OAKLANDS FARM SOLAR PARK

Applicant: Oaklands Farm Solar Ltd

The Applicant's Comments on Written Representations and other
Deadline 1 submissions

Document Ref: EN010122/D3/11.2

3200-3299/3299 Oaklands Solar Farm/Project Files/CAD			
	A	MJ	16.08.23

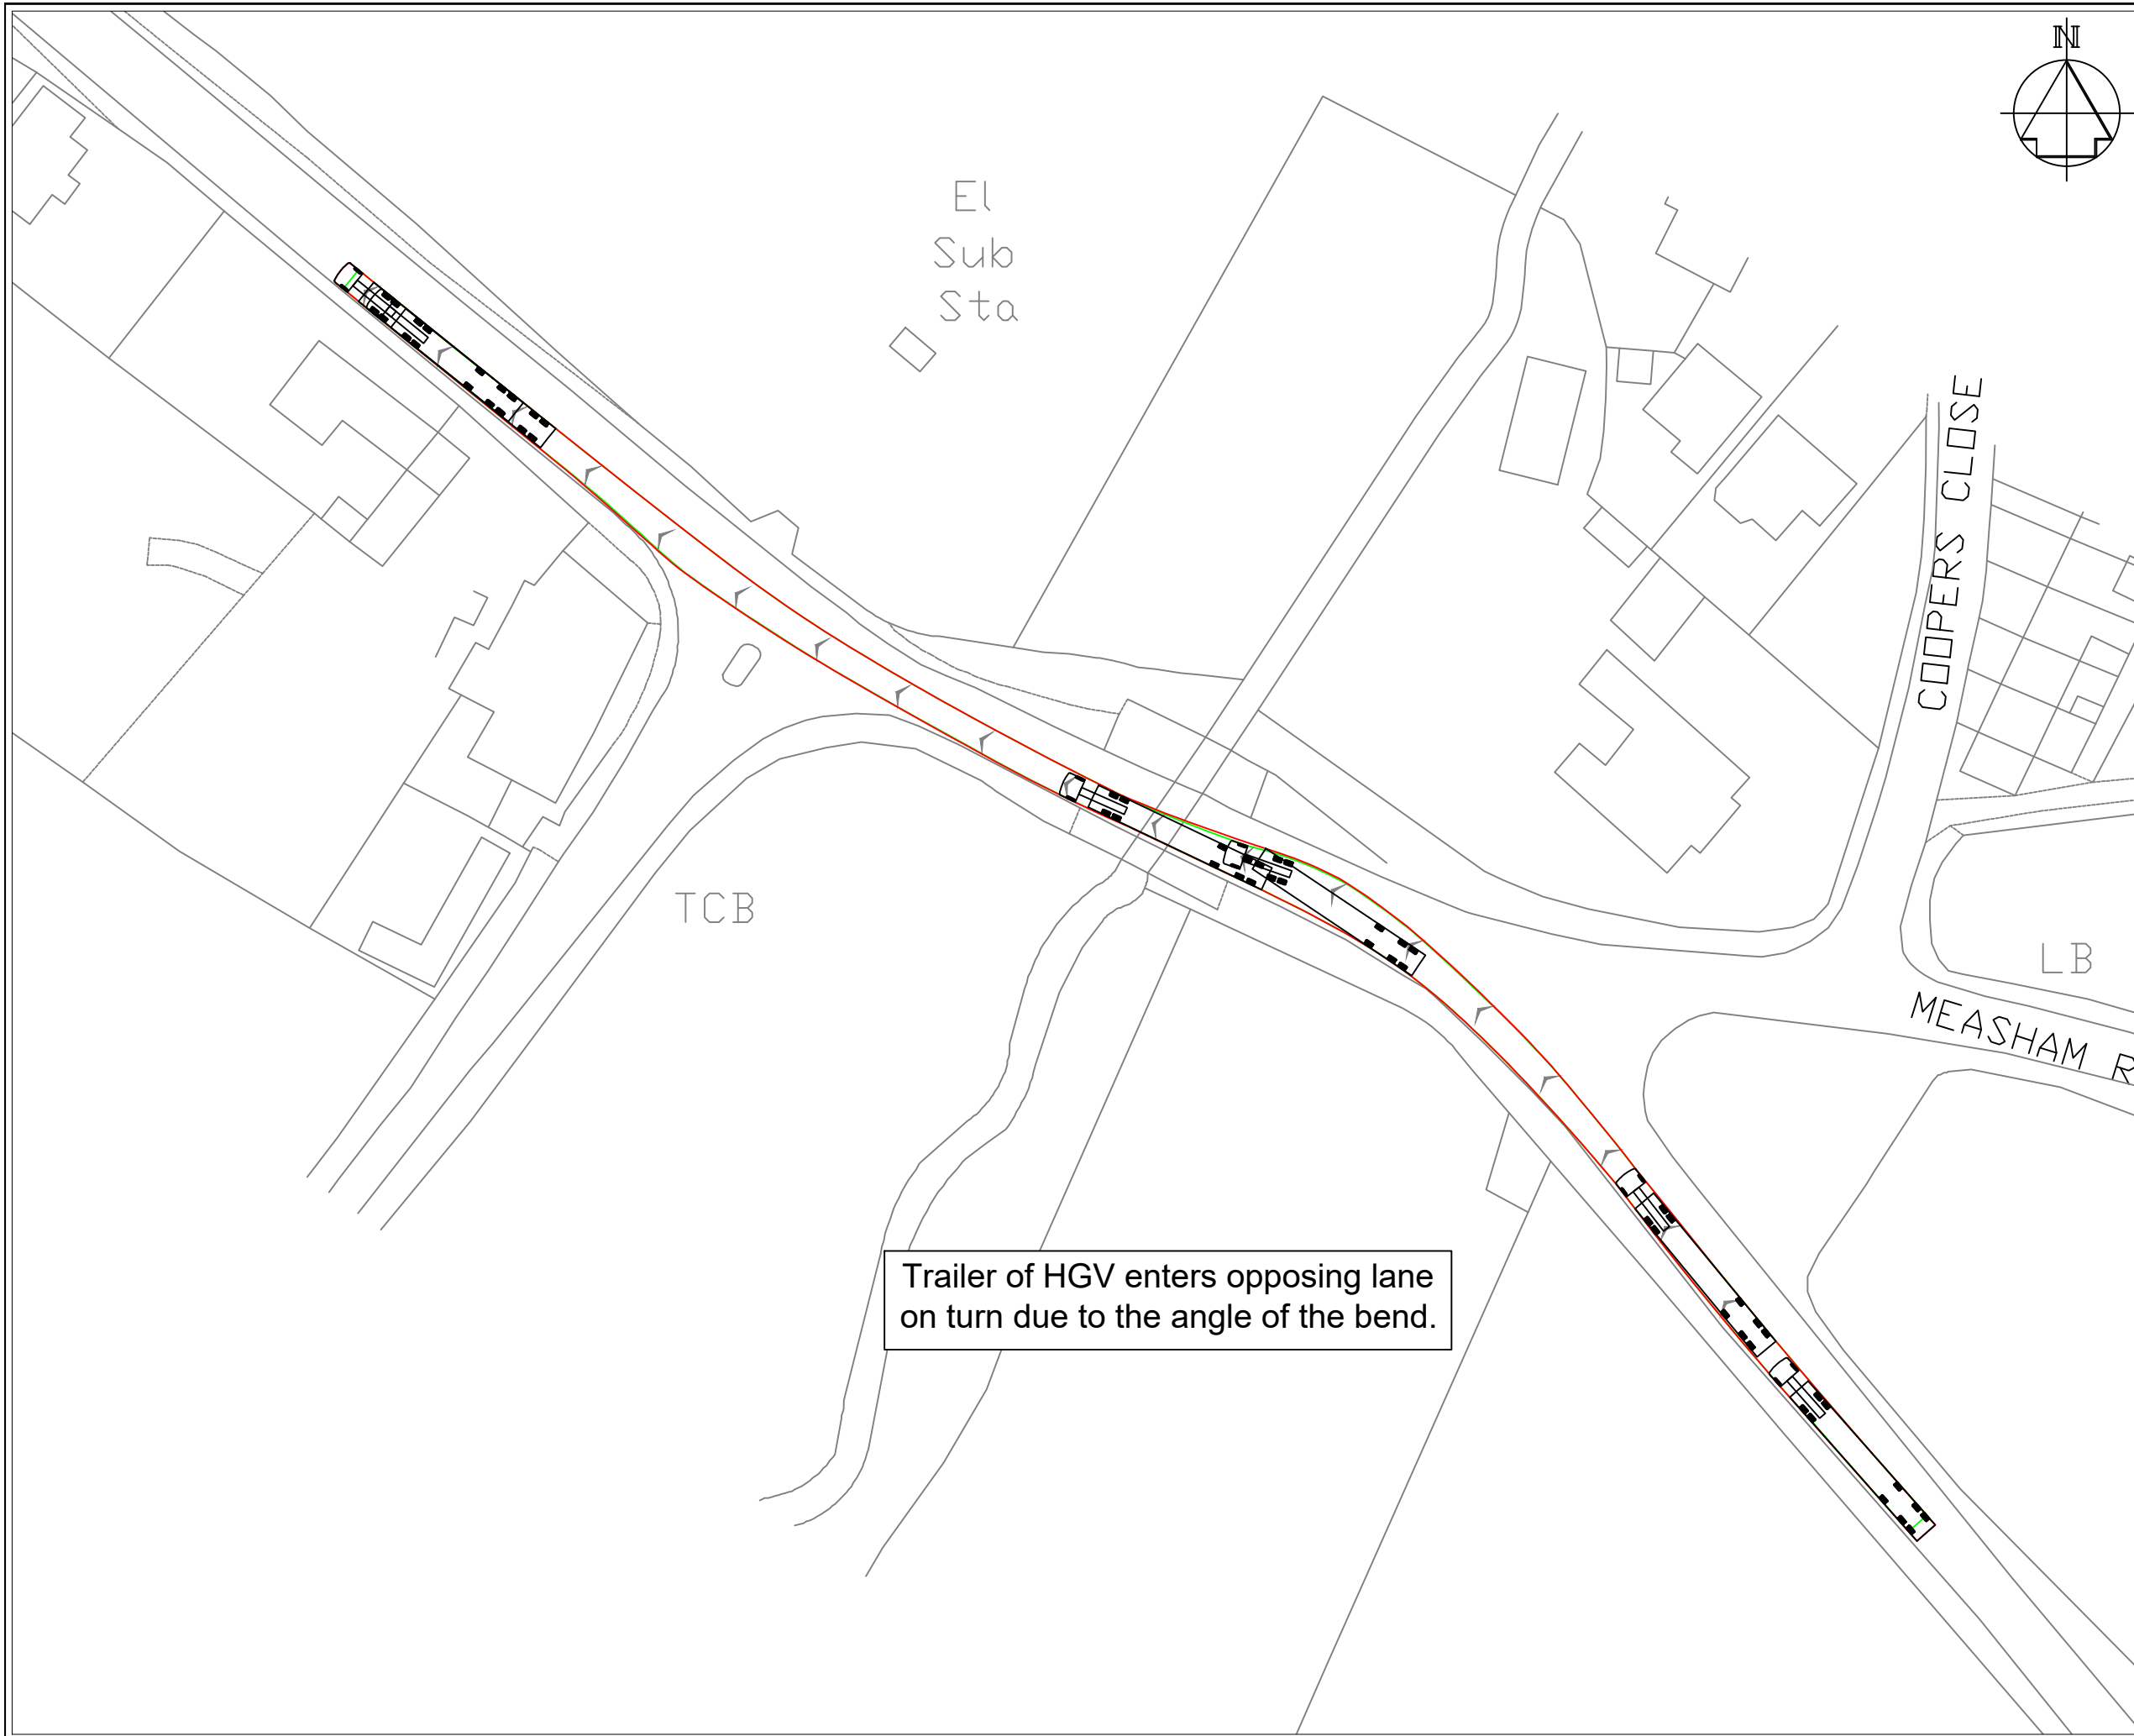
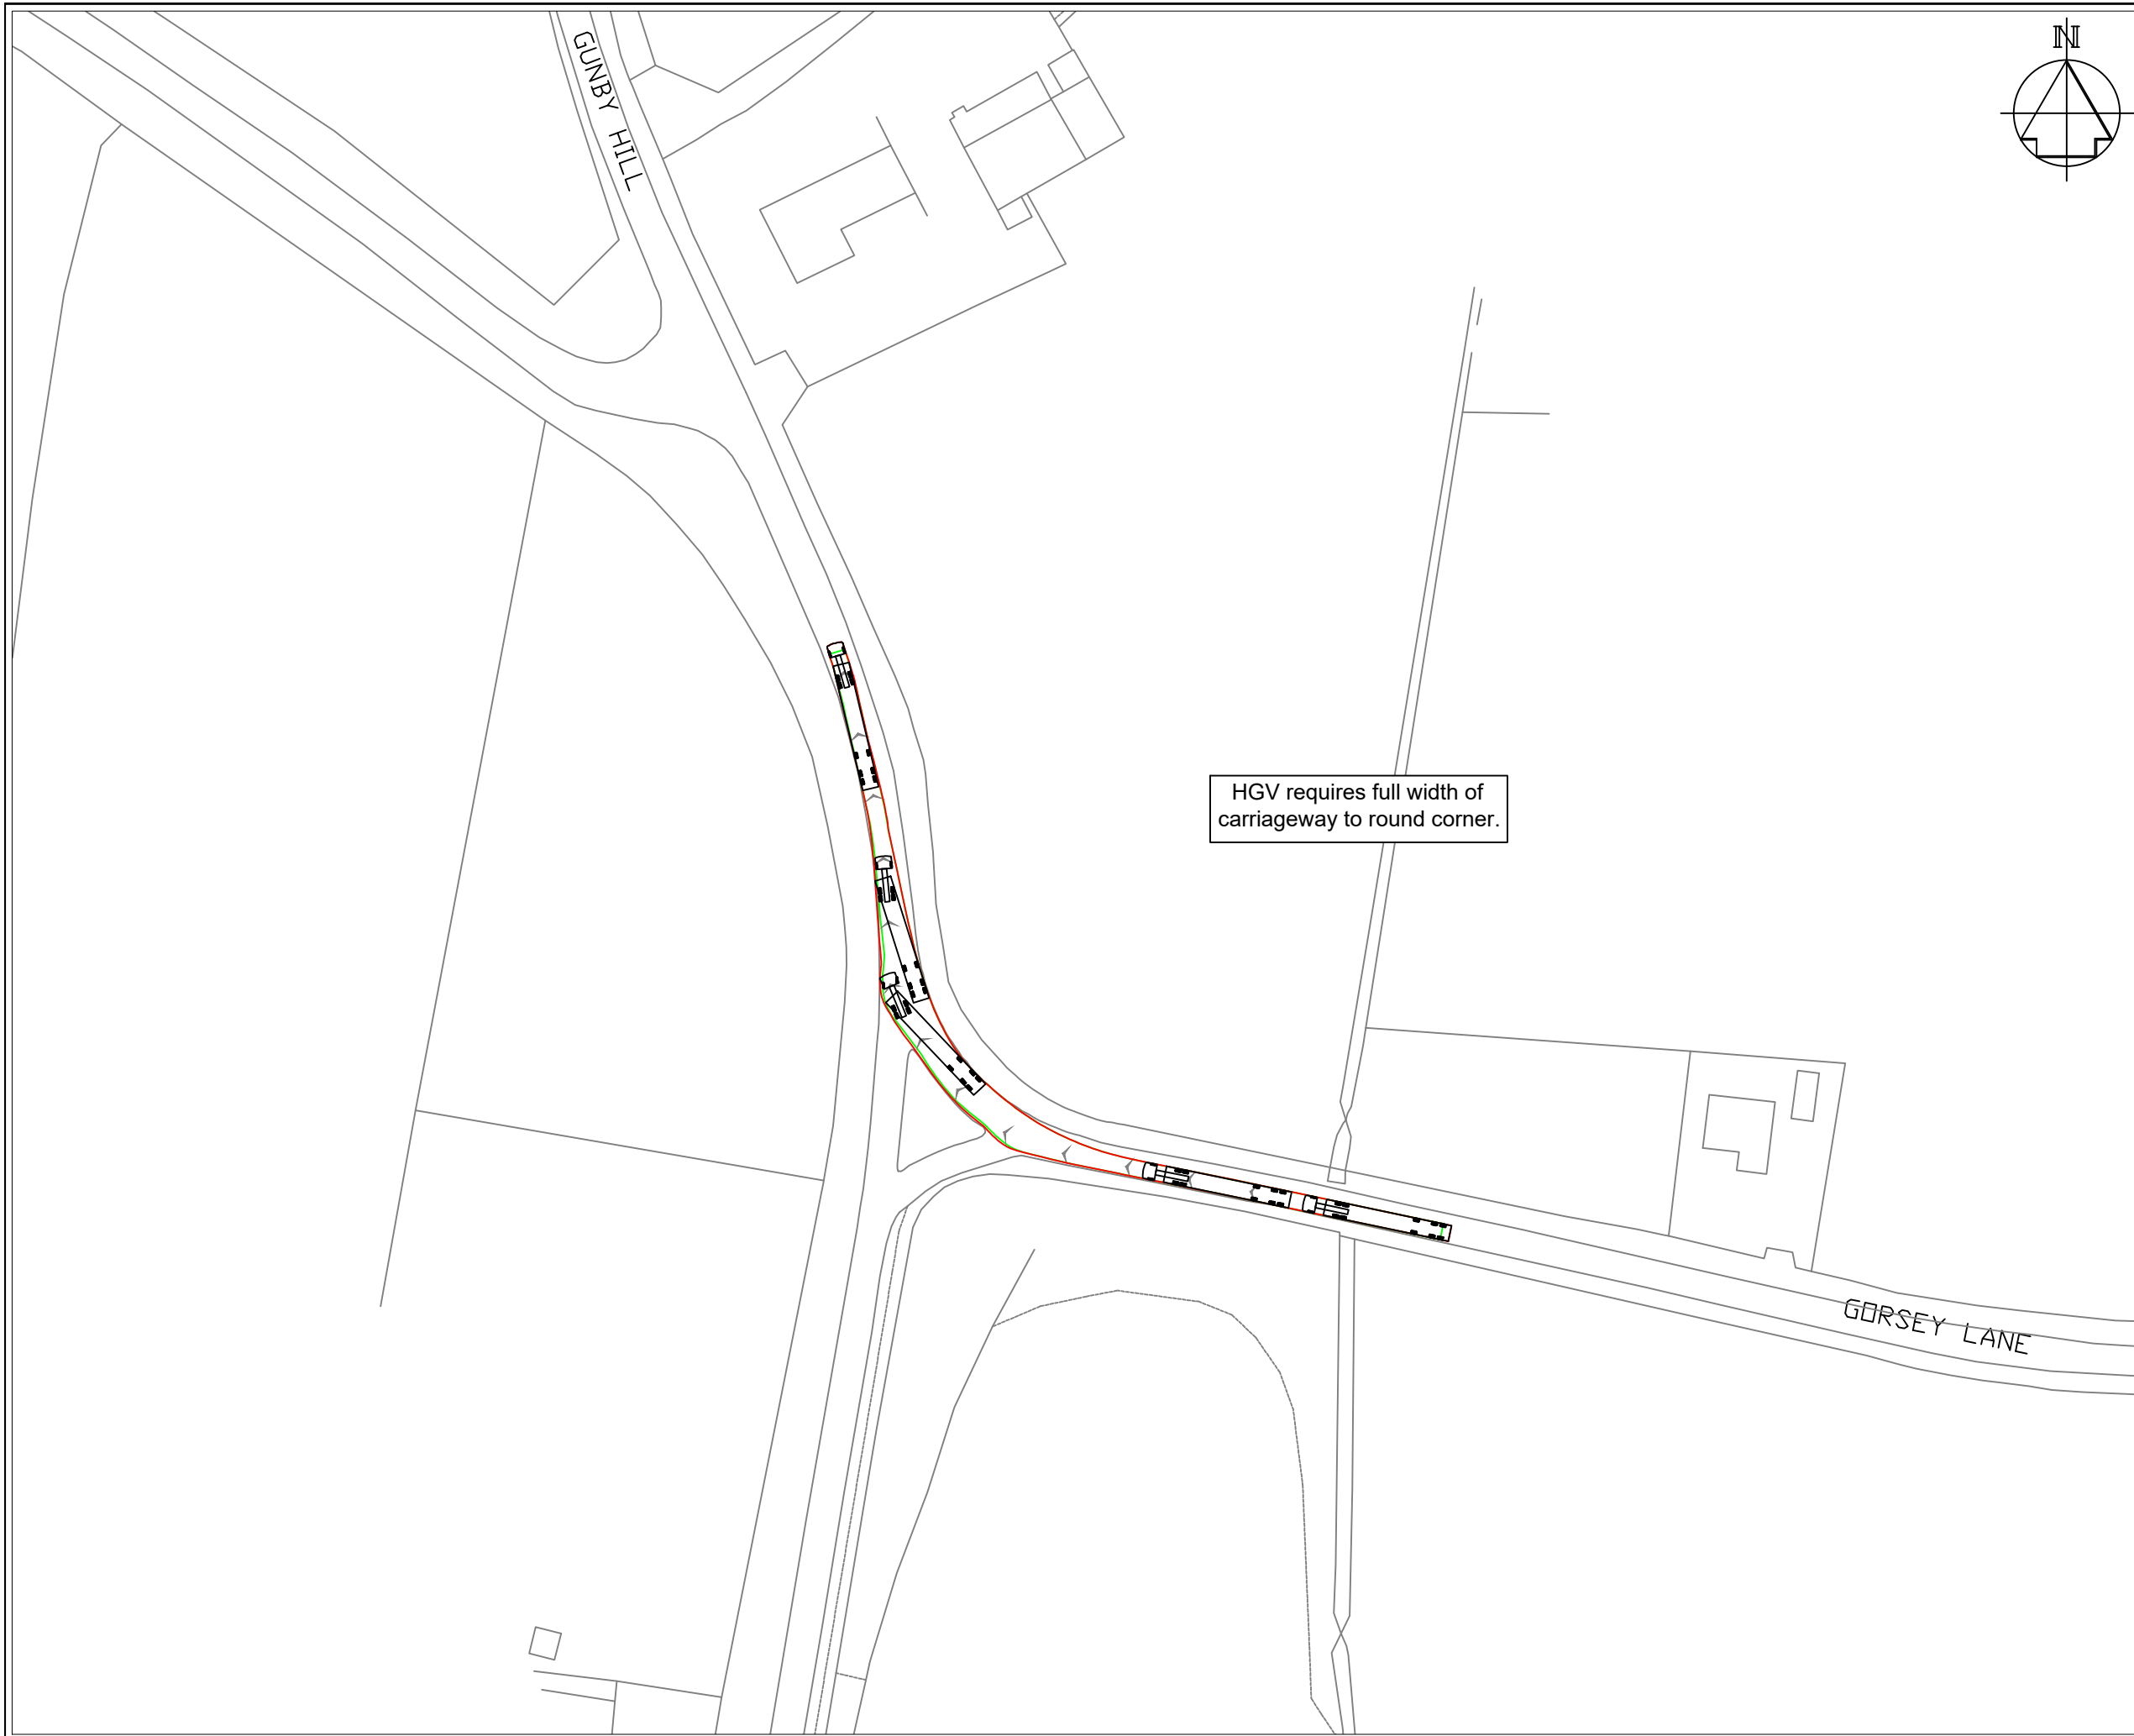
THEME	COMMENT	APPLICANT RESPONSE
Transport	<p>The submitted Environmental Statement (APP-155) states that AIL are proposed to use the Leicestershire Local Road Network (LRN) (A444) between the M42 and Acresford. Whilst these AIL movements are predicted to be limited in number to two (APP155, paragraph 10.154), and are proposed to be Police escorted (APP-155, paragraph 10.156), the submission identifies that surface protection, culvert reinforcement, and temporary removal of street furniture will be required at locations along the route (APP-155, paragraph 10.157).</p> <p>However, the extent and location of such work within the public highway in Leicestershire is unclear. The supporting swept path analysis (APP-154) of which drawing numbers DWG/3299/001 - DWG/3299/005 are relevant to Leicestershire, is labelled as indicative and includes a drawing note which simply states, 'specific vehicle configuration to be checked by specialist haulage company'. Furthermore, the drawings do not appear to be based on a topographical survey and therefore don't identify street furniture etc; neither do they indicate locations of structures e.g., culverts.</p> <p>LCC therefore request that the Applicant engages at the earliest opportunity within this Examination process and confirms the vehicle specification, the associated highway impacts, and the necessary mitigation measures on the LRN in Leicestershire.</p>	<p>The Chapter 10 (Transport and Access) of the Environmental Statement (ES) [APP-155] has assessed the environmental effects for Abnormal Indivisible Loads (AIL). Abnormal load mitigation measures will be secured under Requirement 10 (construction traffic management plan) of the Draft Development Consent Order (dDCO) [REP1-003] in a detailed Construction Traffic Management Plan (CTMP). There is also a legal requirement on the Applicant under the Electronic Service Delivery for Abnormal Loads (ESDAL) system to provide mitigation.</p> <p>The AIL movements will be subject to a separate application and permitting scheme, currently administered by National Highways in consultation with the relevant highway authorities and police. This process will be supported by additional route assessment and validation, including additional surveys as required. Arrangements for further consultation, liaison and monitoring are included in the Outline Construction Traffic Management Plan (OCTMP) [REP1-021].</p> <p>The details of the AIL movements will be confirmed at the detailed design stage once the vehicle specifications are known and the extent of the AIL can be fully assessed in detail. As set out in the OCTMP suitable mitigation measures that will be provided, include:</p> <ul style="list-style-type: none"> • Advanced notification of AIL movement to local residents and businesses. • Temporary Traffic Regulation Order to ensure route remains unobstructed of parked vehicles. • Movement undertaken at a specific time of day in a rolling roadblock format, supported by a police escort to limit the magnitude of impact on identified sensitive receptors. • AIL supported by an escort vehicle along the entirety of its route to warn vehicles and allow the AIL enough time to navigate bends and turns.

<ul style="list-style-type: none"> • Suitable reinforcements of identified culverts within Coton in the Elms, informed by a DCC approved structural engineer report. • Surface padding to protect any areas of overrun including kerbs and verges. <p>The Applicant will be engaging further with LCC during the course of the Examination regarding the detailed CTMP and AIL Swept Path Analysis.</p>
Transport	The Applicant should be aware that the A444 is a Diversion Route for Unplanned Events (DRUE) on the Strategic Road Network (M42) and consideration should be given when planning and programming abnormal load movements.	The Applicant welcomes this comment and will ensure this is included in the detailed CTMP.
DCO	LCC seeks protection of its assets and recovery of any associated costs through provisions within the Development Consent Order. The draft as submitted (APP-016) does not appear to contain the necessary provisions. Indeed, no reference is made to Leicestershire.	The Applicant is required to remediate any damage to the highway network under the CTMP secured by Requirement 10 of the dDCO [REP1-003] . The Applicant will continue to engage with LCC regarding its representation and will provide an update to the ExA at Deadline 4.

Transport	<p>LCC has concerns about the potential impact of AIL movements associated with this development proposal on the LRN within Leicestershire. The information submitted in support of the application is lacking in this regard.</p> <p>LCC note from our attendance at the Preliminary Meeting held on 10th July 2024 that there was a commitment from the Applicant to engaging with Interested Parties, and LCC would welcome engagement as soon as possible to address these concerns.</p>	<p>The details of the AIL movements have been fully assessed within Chapter 10 (Transport and Access) of the ES [APP-155]. The proposed mitigation is set out in the OCTMP [REP1-021] and the final detailed mitigation will be secured in the detailed CTMP as part of Requirement 10 (construction traffic management plan) of dDCO [REP1-003].</p> <p>The Applicant will be engaging further with LCC during the course of the Examination.</p>
